4th February 2020

M25 JUNCTION 10/A3 WISLEY INTERCHANGE IMPROVEMENT SCHEME

PLANNING INSPECTORATE REFERENCE: TROI 0030

TARGETED CONSULTATION ON PROPOSED CHANGES TO THE SCHEME - PRESCRIBED BODIES, LAND OWNERS AND PERSONS WITH INTEREST IN LAND

Change 1 – Extension of the proposed green element on Cockcrow Bridge

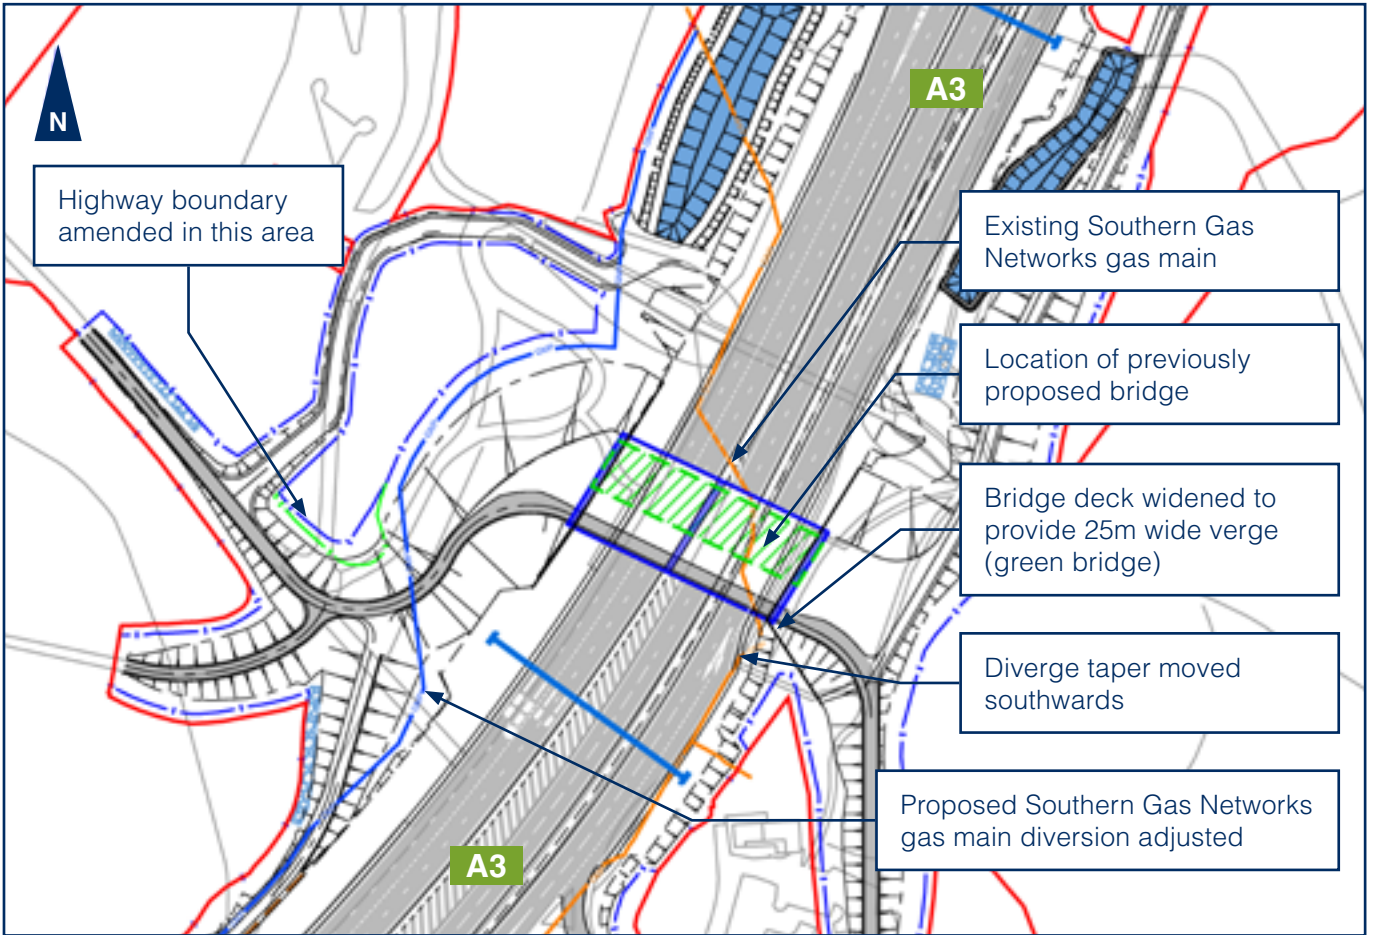
- 1.1 SCC supports the proposal to widen the green verge of the proposed Cockcrow Green Bridge from 10m to 25m as we consider that it is more likely to function as a green bridge, i.e. as a conduit for wildlife across the A3. This will in part help compensate for the fragmentation of habitats and isolation of species that has occurred as a result of the construction of the M25 and the widening of the A3.

- 1.2 SCC would wish to be involved in the detailed design, if this is approved through the Designated Funds process, and would wish to be satisfied that such a structure would not create highways risks e.g. the risk of surface materials being washed onto the highway below and provision of suitable high parapets/fencing to protect any species crossing the bridge and to reduce the impact from lighting and headlights below.

- 1.3 SCC understand that Highways England are to fund the additional maintenance of the green element of the bridge as is the case for the associated green spaces that it links. If it is proposed that SCC are to maintain the green element of the bridge, then the management required to function as a green bridge would need to be agreed along with the appropriate commuted sum to cover maintenance.

- 1.6 It would be helpful if a photomontage of the bridge could be produced for key viewpoints to understand how the green bridge would fit within the existing landscape.

Change 2 – Incorporation of two toad underpasses at Old Lane and other mitigation measures

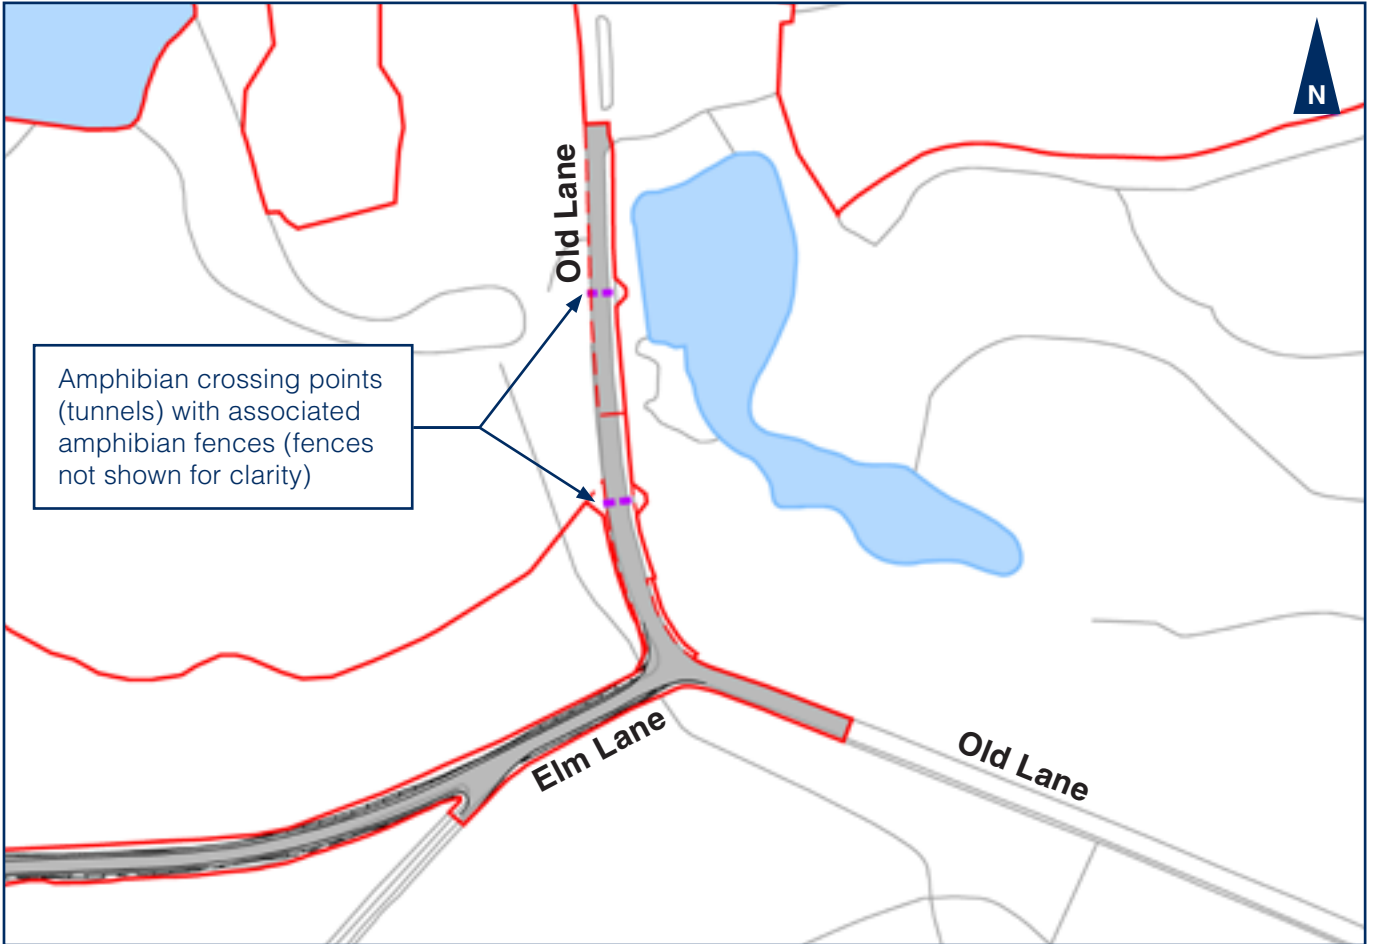
- 2.1 As set out in SCC's Written Representation and the Deadline 3 submission (submission of oral statements at ISH2) - SCC welcomes the proposed revisions to the dDCO to include toad tunnels on Old Lane. Useful discussions have recently taken place with Surrey Amphibian and Reptile Group and Highways England, it has, however, been suggested that the proposed toad tunnel locations and fencing could be better located and that additional underpasses are required to be more effective. SCC would welcome confirmation from Highways England as to how the necessary provision can be best secured to the satisfaction of SCC and the Surrey Amphibian and Reptile Group.

- 2.2 Whilst providing comment on the Old Lane/Elm Lane junction SCC would wish to raise comments regarding Highways England's consideration of road safety at this location. As the scheme proposes to close off the western end of Elm Lane, traffic accessing Elm Lane would have to do so from its junction with Old Lane. SCC would ask if drawings can be provided to show that the required forward visibility can be provided within the red line boundary for both vehicles travelling south along Old Lane to a stationary car waiting to turn into Elm Lane and the forward visibility for a stationary car waiting to turn into Elm Lane towards Old Lane northbound traffic.

Change 3 – Removal of part of the proposed improvements to the A245 eastbound between the Seven Hills Road and Painshill junctions

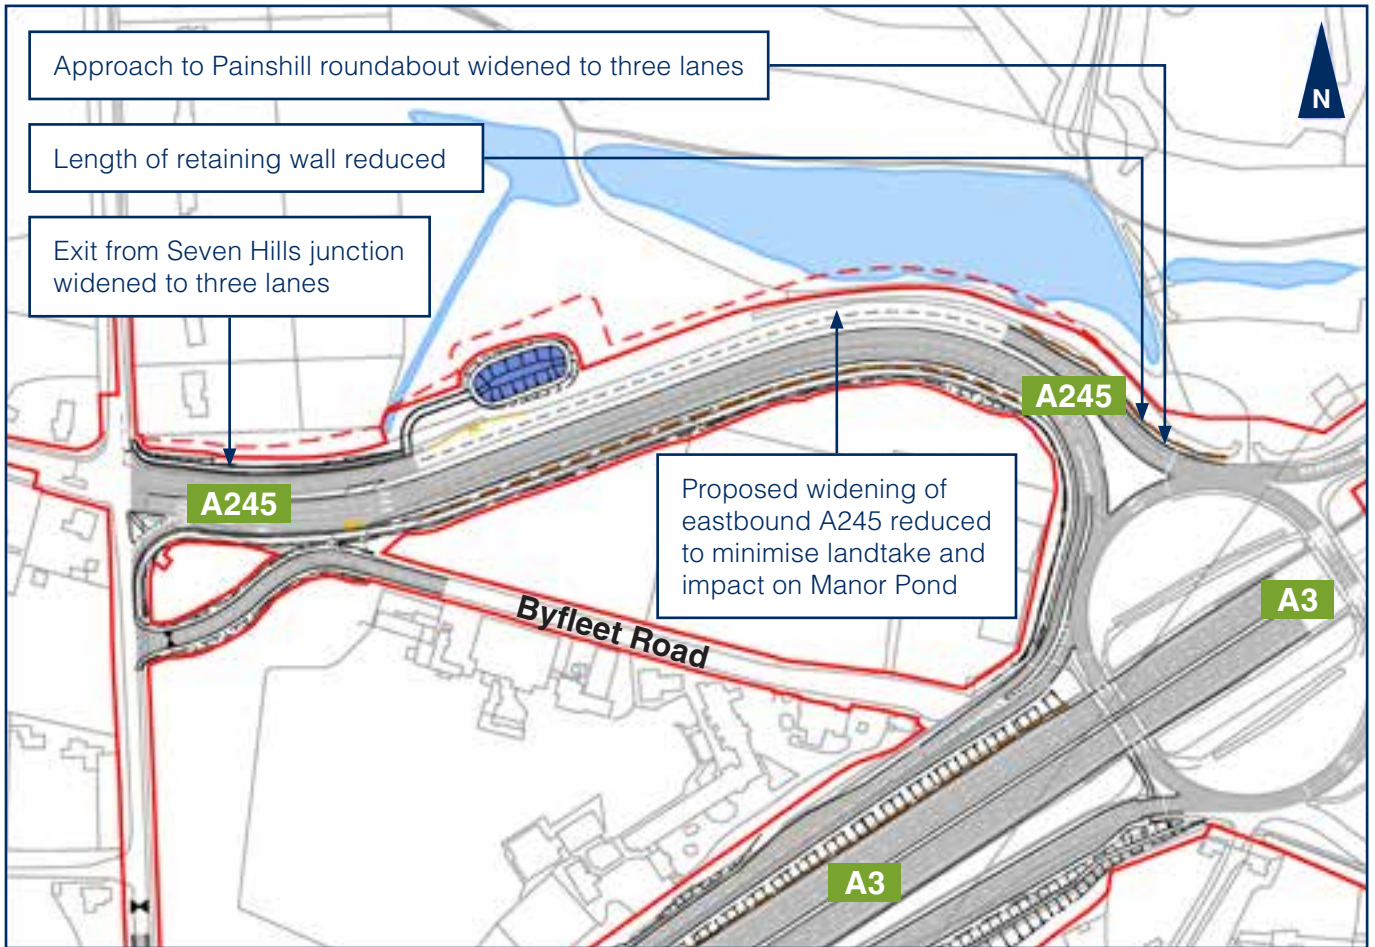
- 3.3 The drawing contained in the brochure does not contain sufficient clarity to define the details at the A245/B265 junction clearly, specifically the A245 eastbound approach into the Seven Hills Road junction; from the drawing it appears as though the nearside lane is left & straight ahead. SCC would therefore like confirmation on both what the original (current) scheme shows and the layout proposed in the revision.

- 3.4 SCC has concerns around the very short three lane section on the A245 eastbound on the downstream (east) side of the junction. As a rule, SCC are trying to remove these downstream merges as they can cause driver conflict. In addition, SCC would tend to have the merge on the offside so traffic in the right hand lane merges into the middle lane: we do not like it when nearside traffic merges with offside traffic as it can push vehicles further to the right and potentially into the on-coming stream (or in this case into the right hand lane). As such we would expect the merge as proposed would be acceptable.

- 3.5 The main point, however, is that merges on the downstream side of the junction, unless somewhat distant from the junction and with a gradual merge (see next point below), can cause delay which impacts upon the flow through the junction. In such cases, appropriate underutilised green time in the relevant stage should have been incorporated in the LinSig model to reflect a reduced saturation flow due to issues on the downstream side affecting flow through the junction. It is not possible for SCC to verify this without access to the traffic model. SCC's specific concern is that any reduction in capacity on the eastbound approach to this junction will have impacts on the congestion experienced by drivers travelling eastbound on the A245 from the Brooklands area.

- 3.6 The length of taper on the downstream of the junction should be at least 100m from the downstream edge of the junction intervisibility zone as stated in DMRB CD 123 (August 2019). It is not possible for SCC to check this on the drawing provided in the brochure, but it appears as though the merge is considerably shorter than 100m.

- 3.8 In summary, the level of detail provided is insufficient for SCC to fully comment on the proposed revision. In addition to the modelling requests made above, SCC also require a copy of the RSA along with more detailed drawings in order to fully understand the lane details at the A245/B265 junction specifically.

Change 5 – Amendment to the speed limit at Elm Lane (and including Byway 525 – Byway Open to All Traffic)

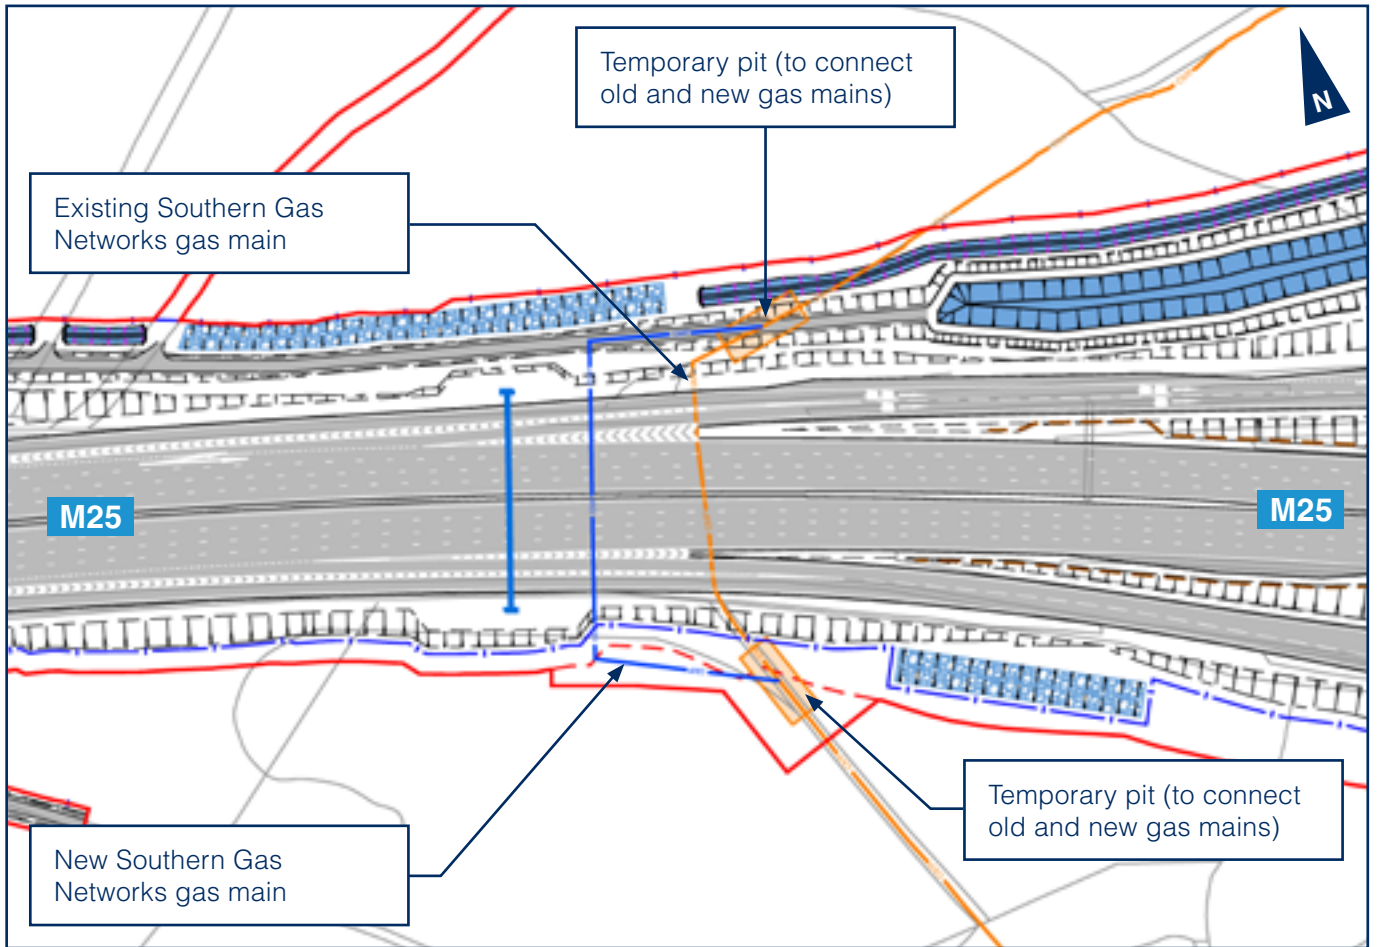
- 5.1 As set out in para 7.8 of Joint Authorities Local Impact report SCC welcomes the proposed change to dDCO submitted on 4th November 2019 (Change 6 of AS-023) that amends the speed limit to 20mph on Elm Lane.
- 5.2 SCC would welcome comments from Highways England as to how actual speeds along Elm Lane would meet the amended/posted speed limit to reduce the impact on amphibians crossing the new section of Elm Lane.
- 5.3 See also SCC comments made in para 2.2 of this letter.
